East Midlands Gateway

Document Review – Landscape and Ecological
Management Plan (LEMP)

- 1.3 The LEMP (APP-117) (Document DCO 6.9J/MCO 6.9J October 2025) was downloaded from the Planning Inspectorate website on 23rd March 2026 and the following reports on the finding of the review undertaken to respond to the Examining Authority questions above.

Table 4: Works Schedule

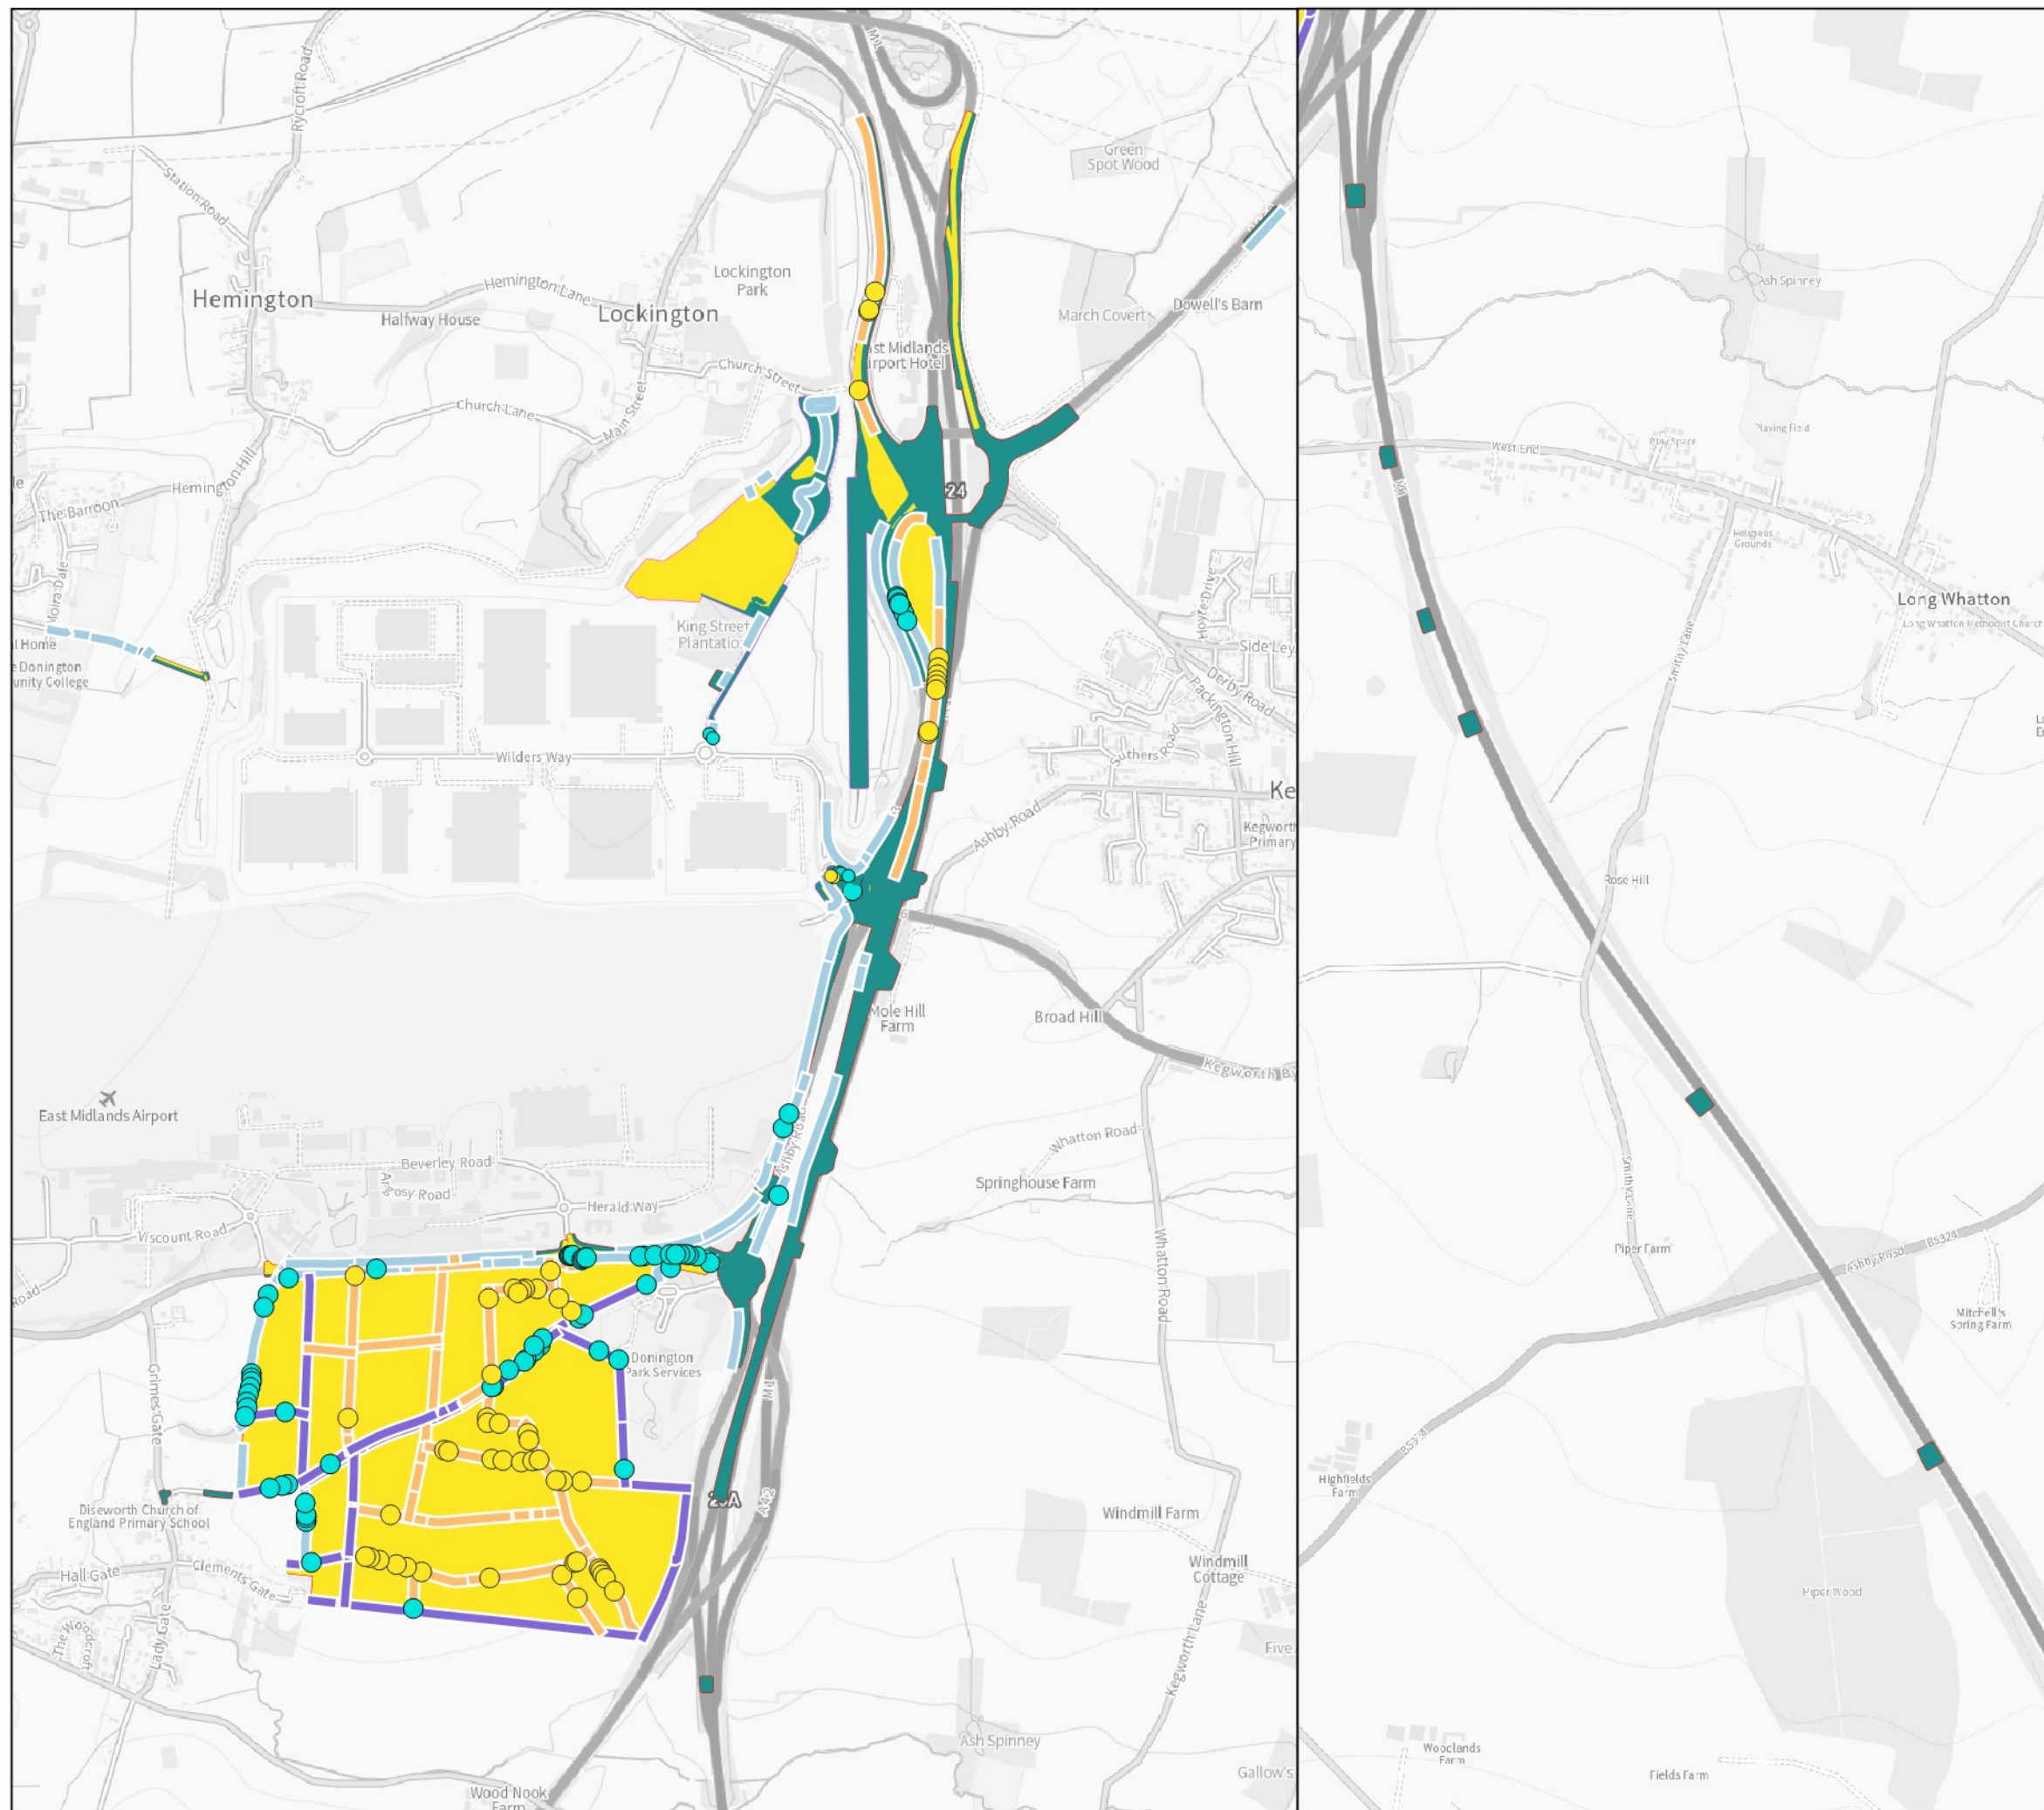
- 2.52 Suggest planting season be extended to March as previously noted.
- 2.53 Suggest a second (autumn) window for creations of grasslands e.g. Sept/Oct sowing may be useful.
